Application H16-1051-25
Location LLOYDS TSB BANK PLC 15 MARKET PLACE SPALDING PE11 1SF
Proposal External handrail to entrance steps

Name Imogen Colenutt, Assistant Conservation Officer
Address Council Offices The Hub Mareham Rd LN9 6PH

PROPOSED HANDRAIL ELEVATION
Scale 1:50

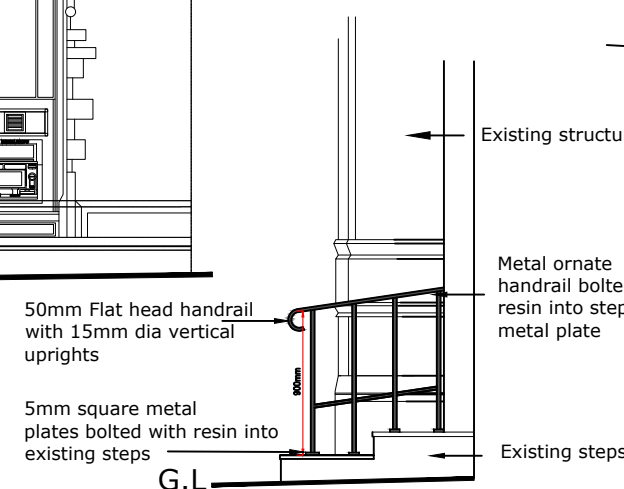
While the works will result in a degree of harm to the listed building due to the requirement to drill into the existing stone steps, this harm is considered to be less than substantial in heritage terms. The overall design of the proposed handrails appears discreet and constructed from materials that complement the character and appearance of the building.
